From: Anita Gardner
Sent: 27 April 2012 09:01
To: Planning.Responses
Subject: FW: AB/36/12/DOC and AB/47/12/DOC- Arundel Museum Site

From: Anita Gardner
Sent: 26 April 2012 10:58
To: Ian Brewster
Subject: AB/36/12/DOC and AB/47/12/DOC- Arundel Museum Site

Arundel Museum – Site set up plan

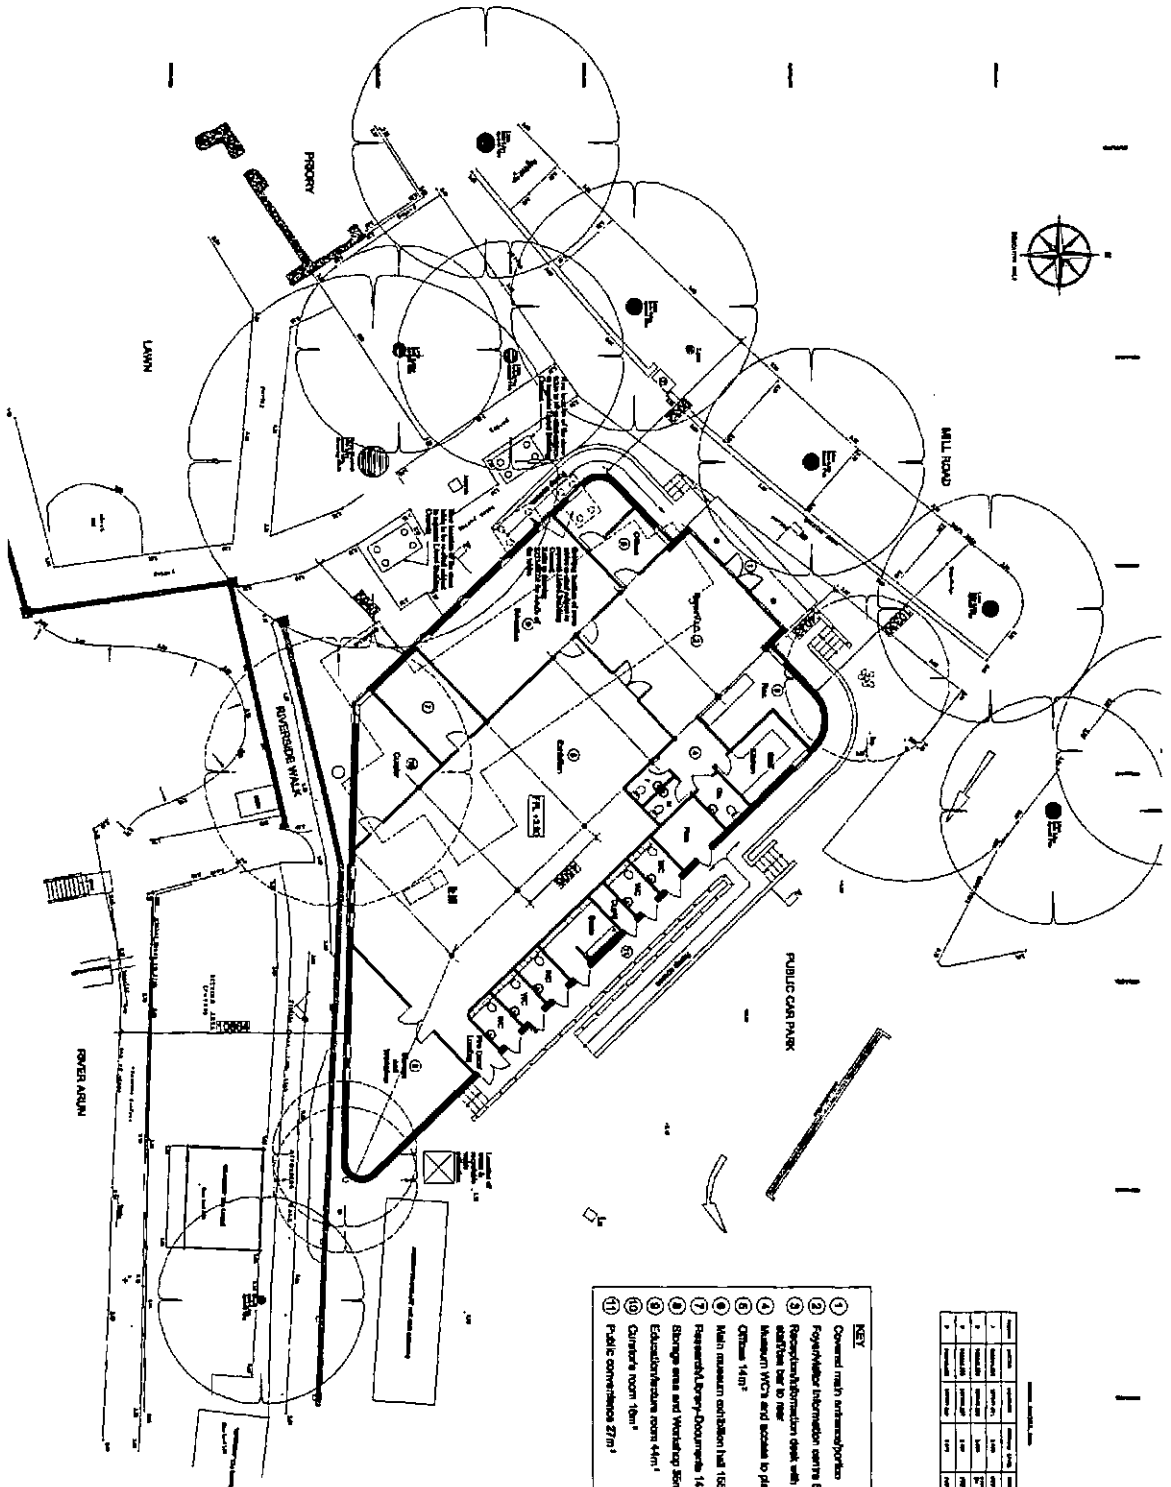
Mondays meeting with the site manager and archaeologist revealed those trees to be protected, and in particular the mature Horse Chestnut, to be suitable provided for in accordance with the plan and BS5837 (2005).

Ian,
There isn't a condition specifically relating to trees, but the plan drawing no.2353/100B indicates root protection zones.
Anita

I believe you met on site earlier this week with the County Archaeologist and agreed the trial pits in relation to RPZs. Please can you let me have confirmation in writing to advise if the conditions which include the root protection plan can be discharged.
